**CITY OF PORTLAND, MAINE**  
**HISTORIC PRESERVATION BOARD**

March 18, 2013

Re: Front and side stair replacement, site alterations; 44-50 Park Street

See revision-
retaining wall
3/25/13

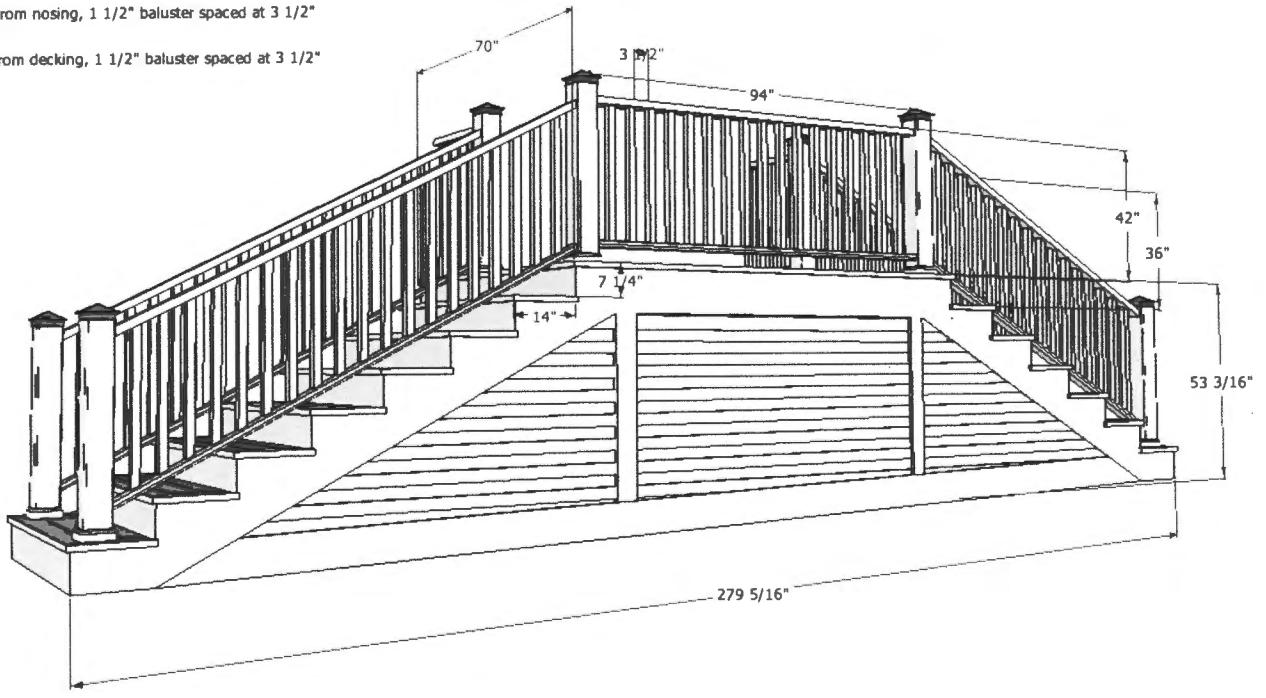
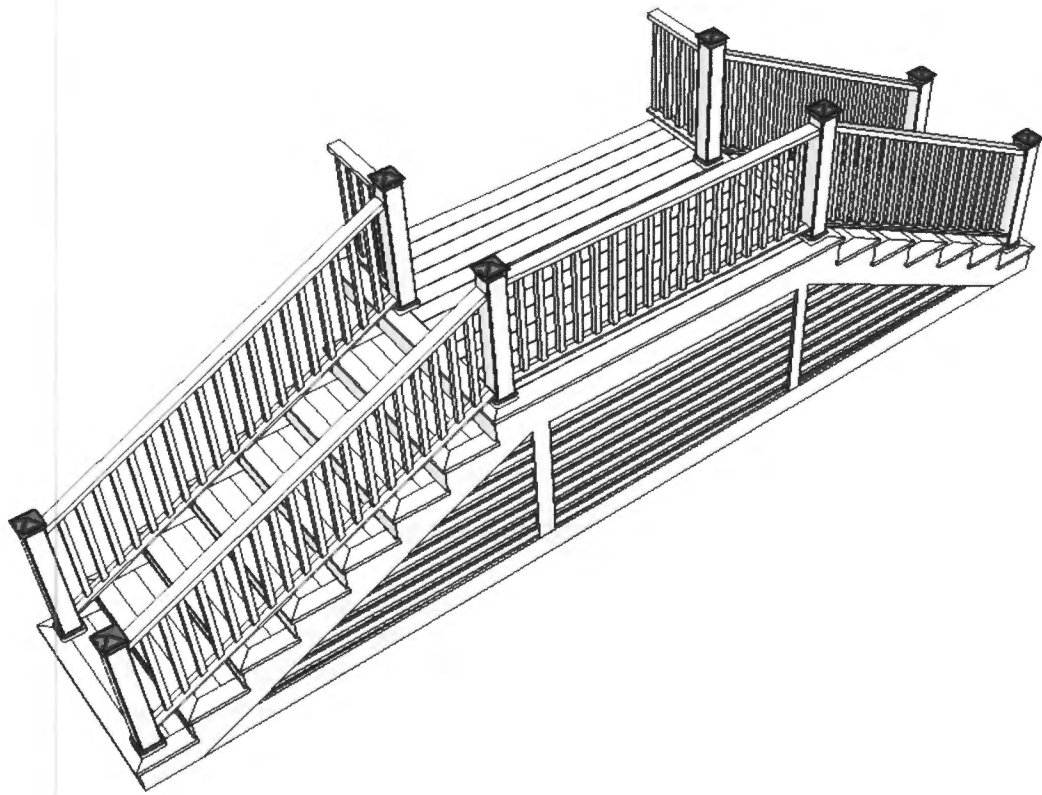
- Applicant to provide a detail of the front yard retaining wall showing replacement of the stone wall with granite curbing.
- The front yard curbing shall not be set back on either side of the front steps as shown on the submitted drawings. Instead, the curb shall run in a continuous line, directly abutting the bottom step, which shall be a piece of granite that projects slightly beyond the front face of the curbing. Applicant to provide elevation and plan drawings to show details.

- Where the stone wall returns toward the rear of the house at the lower end of the front yard, the wall will revert from curbing to a stone wall similar to the present wall, but sloping upward in steps to retain the embankment to be installed to cover the rubble sub-foundation. This wall at the side of the parking area shall extend toward the rear of the property, and terminate under the front posts of the side entry landing.

- Design of rear retaining wall to be revised to feature a stepped wall treatment. The front section of wall is to be kept low (curb-height or slightly higher) and is to match the character of the side yard stone wall. Beyond this short wall, a planting bed for shrubs is to be installed. Behind the planting bed, a second, taller wall may be constructed at a height to meet the overall height of the existing wall. This second wall may be made up of interlocking concrete blocks, as it will not be readily visible behind the shrubs.
- The existing wood fence may be reinstalled, but the applicant is encouraged to modify its design by cutting off the top pickets and installing a wood cap to provide a more finished appearance. If an alternative fence is proposed, applicant to provide a specification for approval.
